From: Laura Gibbons <Laura.Gibbons@arun.gov.uk>
Sent: 09 February 2021 10:09
To: Planning.Responses <Planning.Responses@arun.gov.uk>
Cc: Raymond Cole <Raymond.Cole@arun.gov.uk>
Subject: RE: Planning Consultation on: WA/99/20/DOC

Application No: **WA/99/20/DOC**

Registered: 5th January 2021
Site Address: Land To East Of Fontwell Racecourse Fontwell Avenue Eastergate BN18 0SW
Description of Works: Approval of details reserved by condition imposed under ref APP/C3810/V/16/3143095 (WA/22/15/OUT) relating to Condition Nos 6 - materials and finishes, 12 - surface water drainage, 13 - infiltration of surface water drainage, 14 - maintenance & management of SuDs, 15 - foul drainage and 27 - emergency access from site onto Arundel Road.

Drawing No. FON-130-04-D

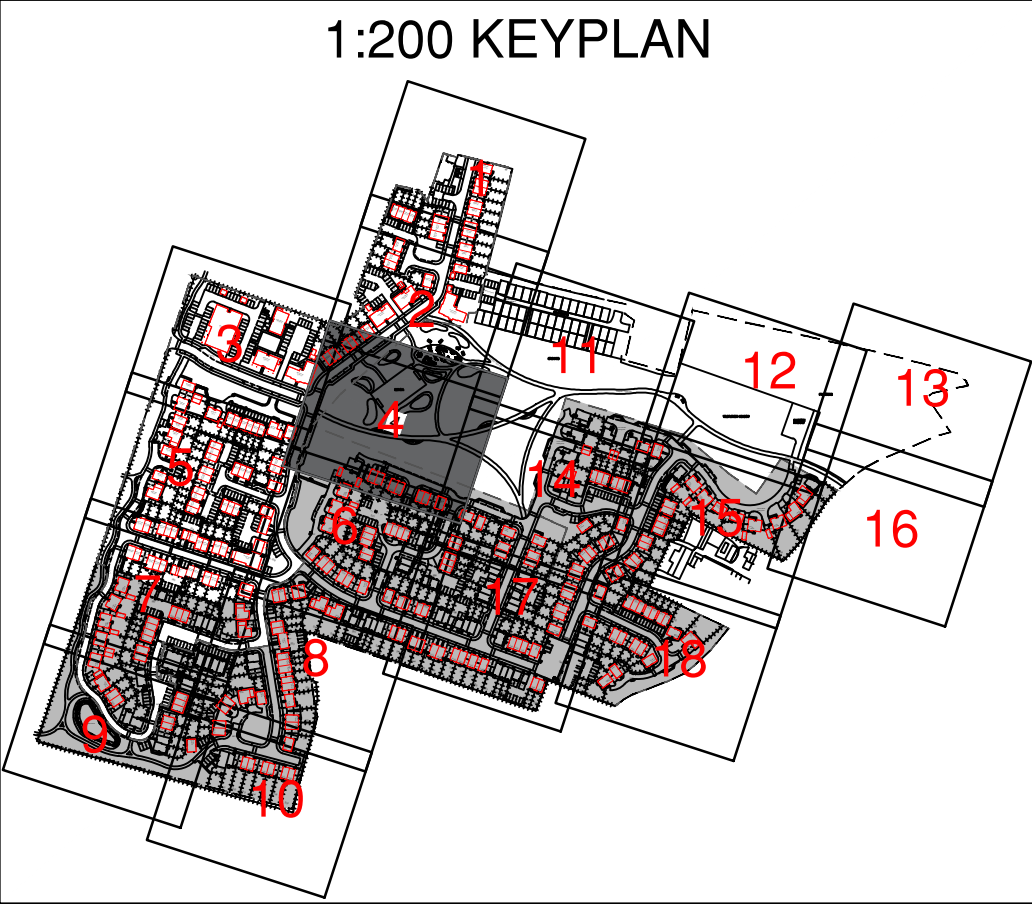
1. Please provide catchpits upstream of all soakaway features, e.g. PS218 needs to be a catchpit, and so on.
2. It may also be beneficial to show the soakaway dimensions on the domestic drainage layouts.
3. Where connections are being made to pipelines rather than direct to manholes – add note ‘all connections to be made using oblique 45 degree junctions’
4. The invert and base levels of some soakaways seems to have significantly decreased since the RM details. Please elaborate on why this is the case, if you are confident all soakaways have a base level above peak groundwater level, and if soakaways can be raised up. For example, soakaway 5 which is serving area 13 has had its base level dropped from 23.3 to 21.42, minimum falls of pipes do not appear to have been used throughout. And the base appears to be at or below groundwater recordings in the area WS205, WS206 and

WS105 are all around this point, with WS205 potentially being closest which had a peak seasonal groundwater level of 23.8mAOD.

Drawing No. **FON-180-01**

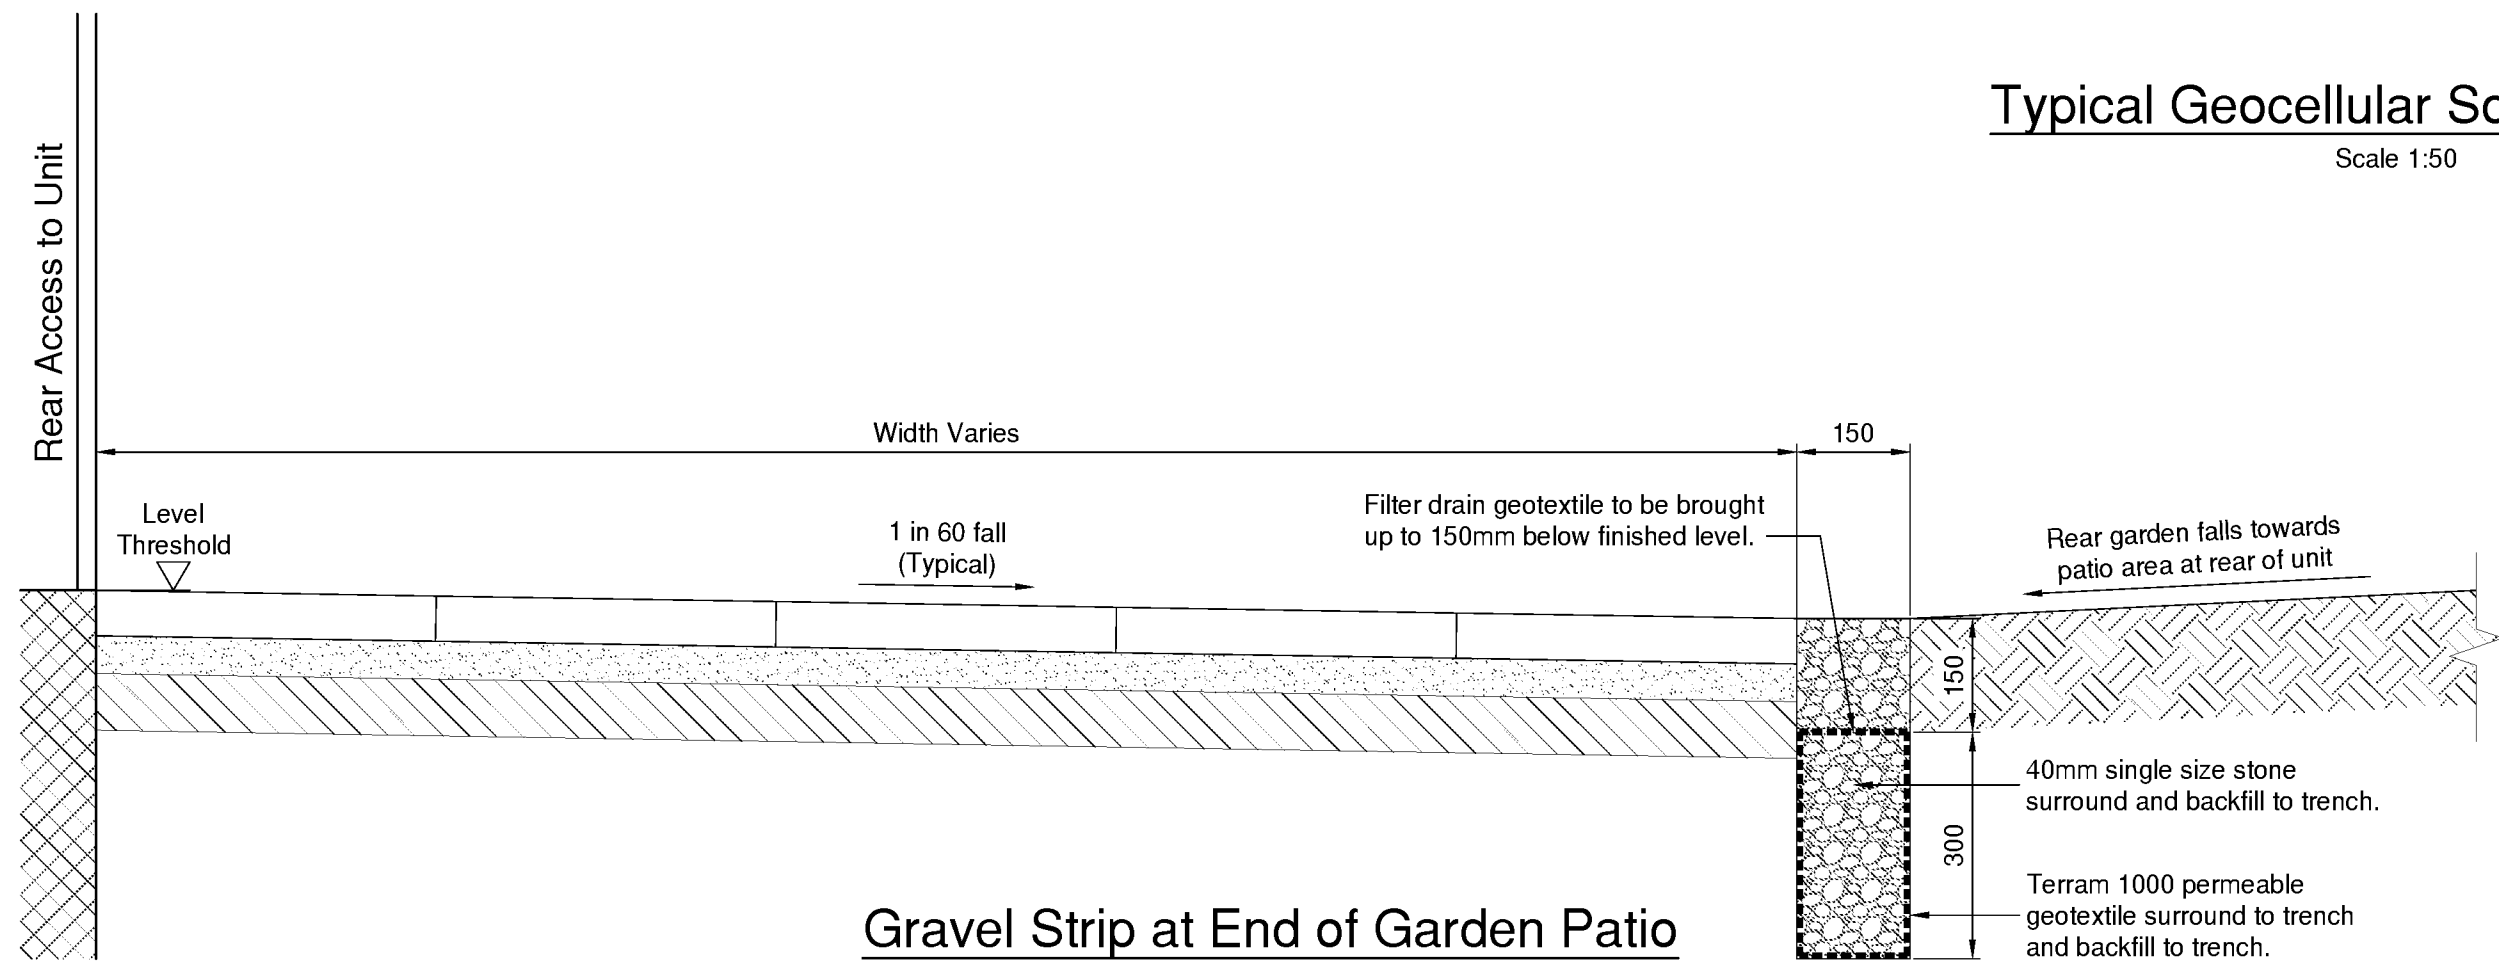
5. Please provide a construction detail drawing of the permeable paving with check dams.
6. Please confirm if lengths of road without check dams are appropriate. There is a considerable fall over the site, and only small regions are to have check dams.
7. Please detail finish and formation level of permeable paving car park areas.
